Our reference : FIL08/16350: DOC08/61451:JB
Contact : Jen Byrne (02) 4224 4100

**EXHIBITION OF ENVIRONMENTAL ASSESSMENT
PROPOSED DIESEL STORAGE FACILITY AND REFUELLING STATION AT
WEST CLIFF COLLIERY (MP 08 0151)**

GENERAL ARRANGEMENT

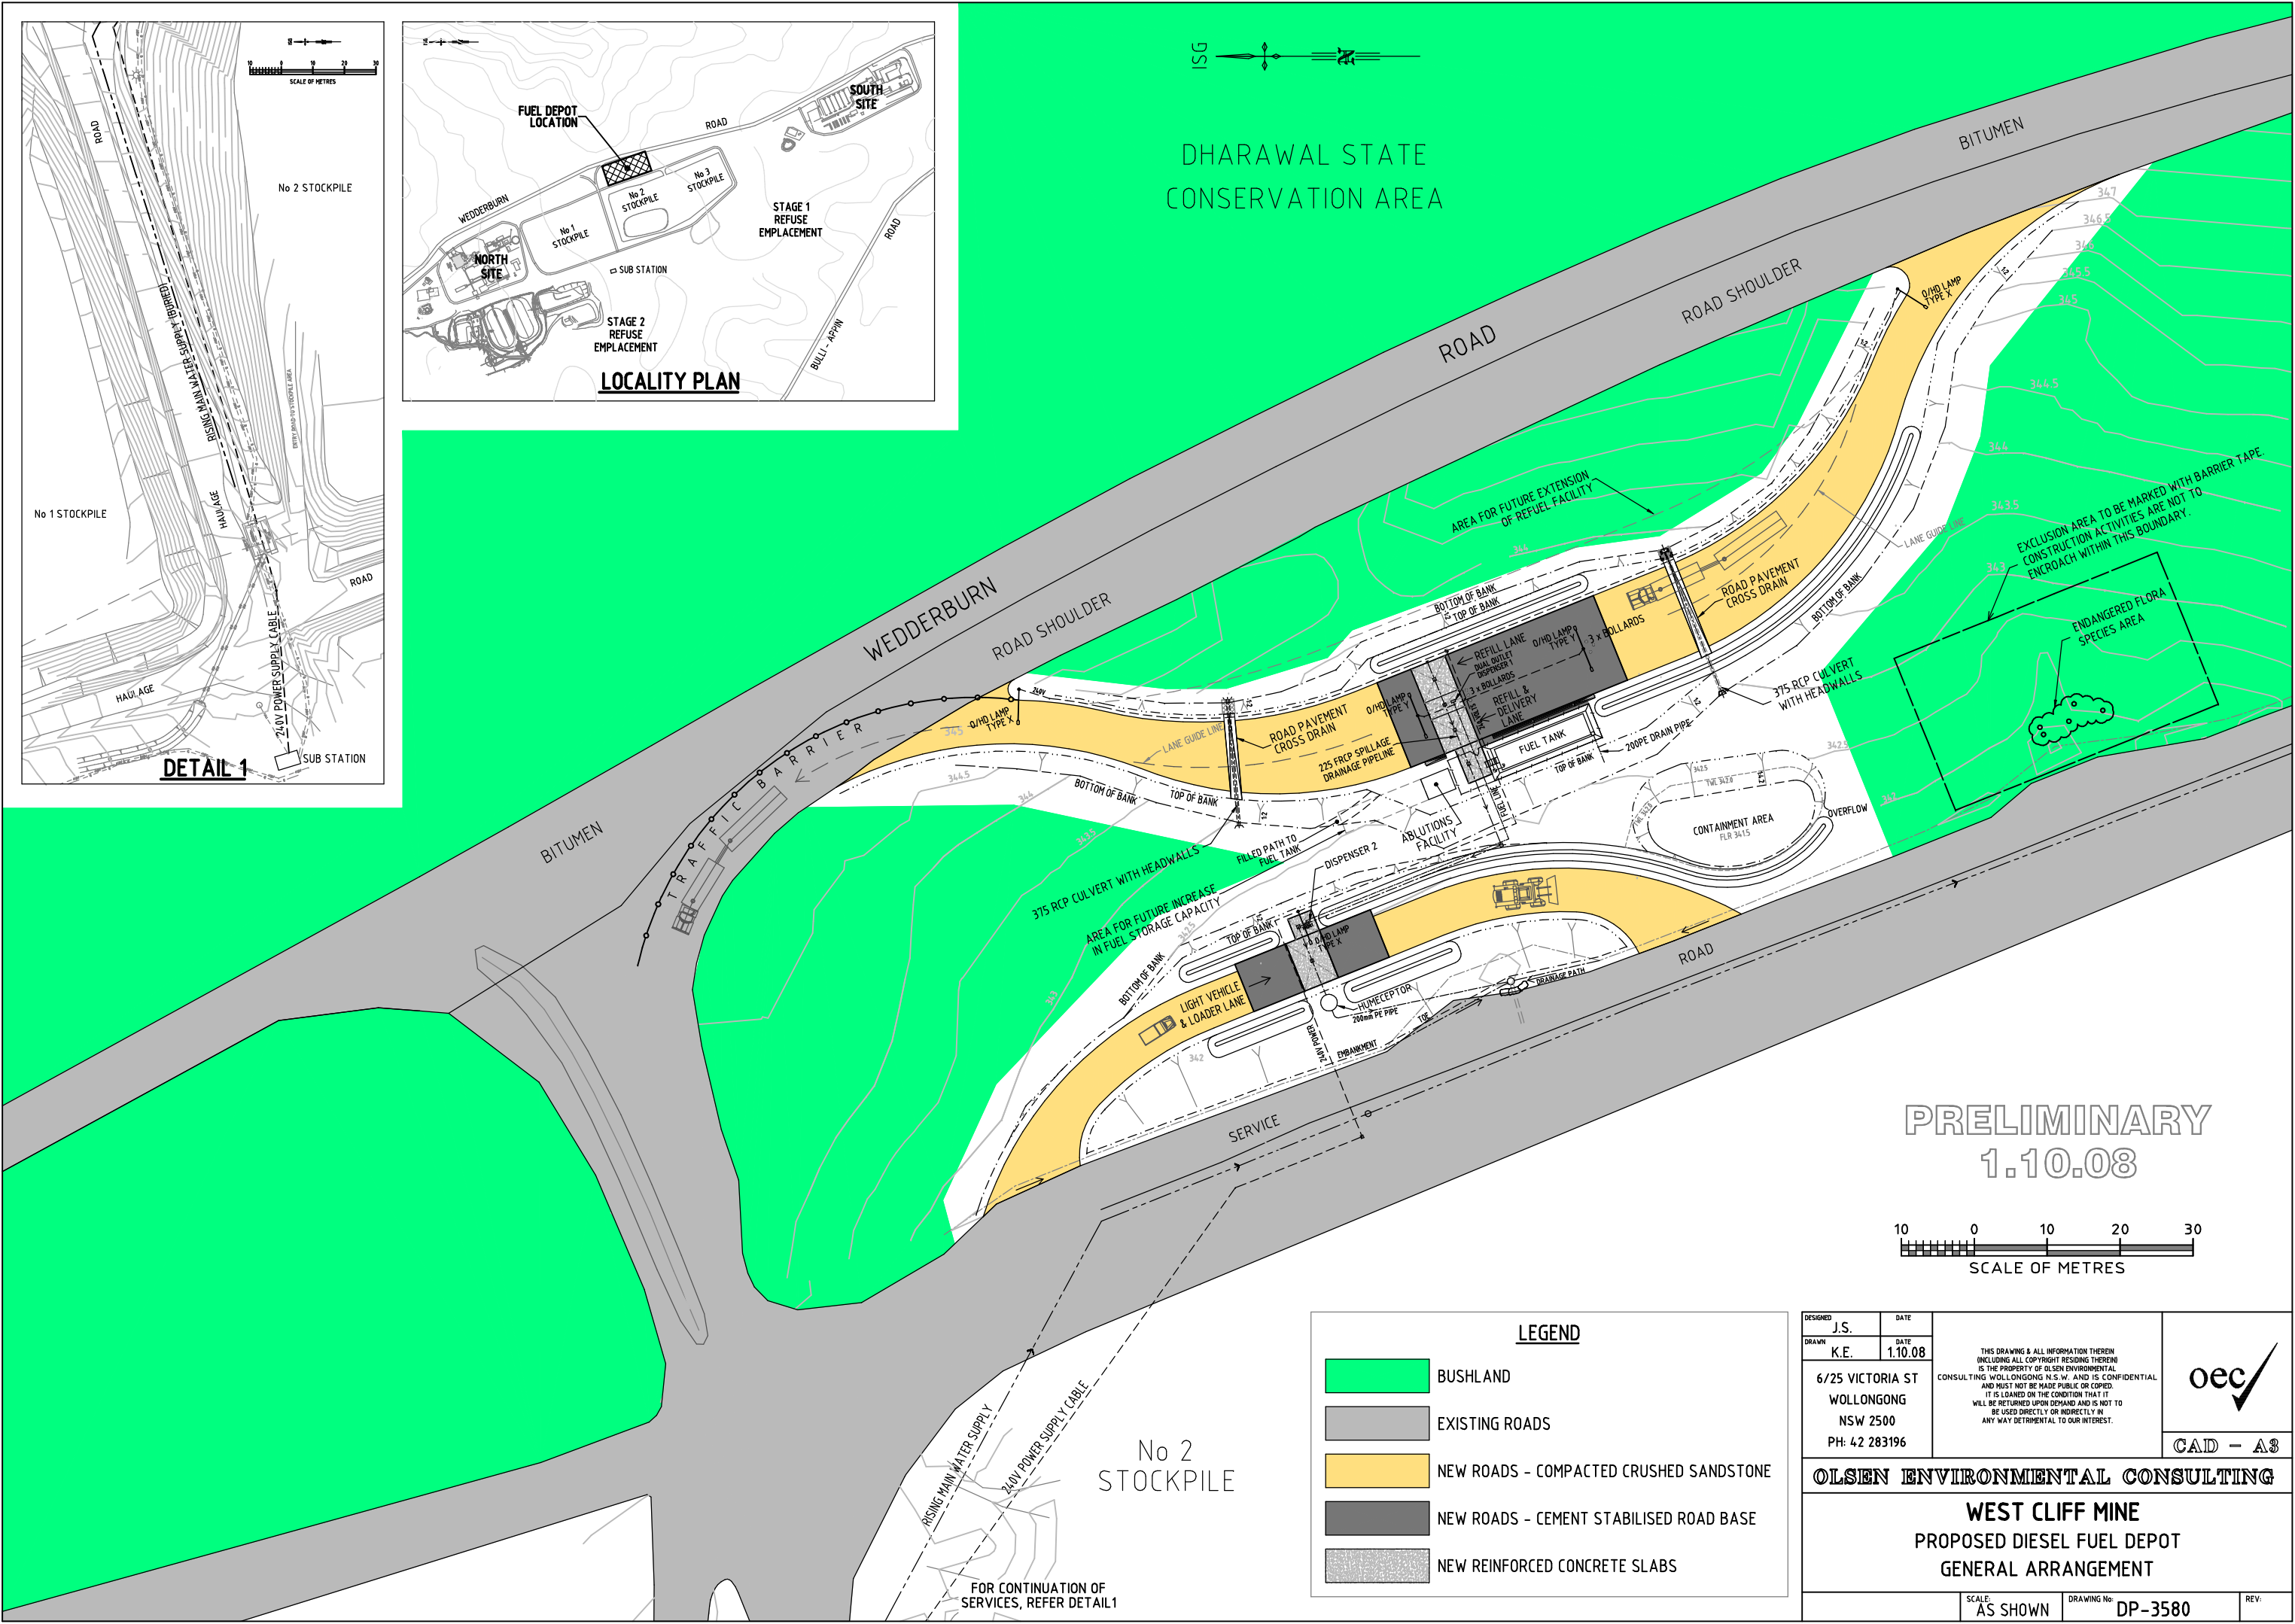
We note the EA identified that the proposed development will require the construction of a primary spillage collection pond that overflows into Pond 1. It is unclear from the EA whether the primary spillage collection pond will have either sufficient capacity to prevent overtopping or to dry out and allow any spillage solids/sludge to be collected.

- Clarification of the capacity of the primary spillage collection pond will be sufficient to manage any diesel spillage without discharge under a range of operational scenarios and climatic conditions as represented by local historical rainfall and evaporation data.
- Clarification that the primary spillage collection pond will be designed to permit any spillage solids/sludge to be periodically collected and transported off-site for disposal (eg through being sized sufficiently to allow periodic drying-out of the pond, pumping water between ponds, etc).
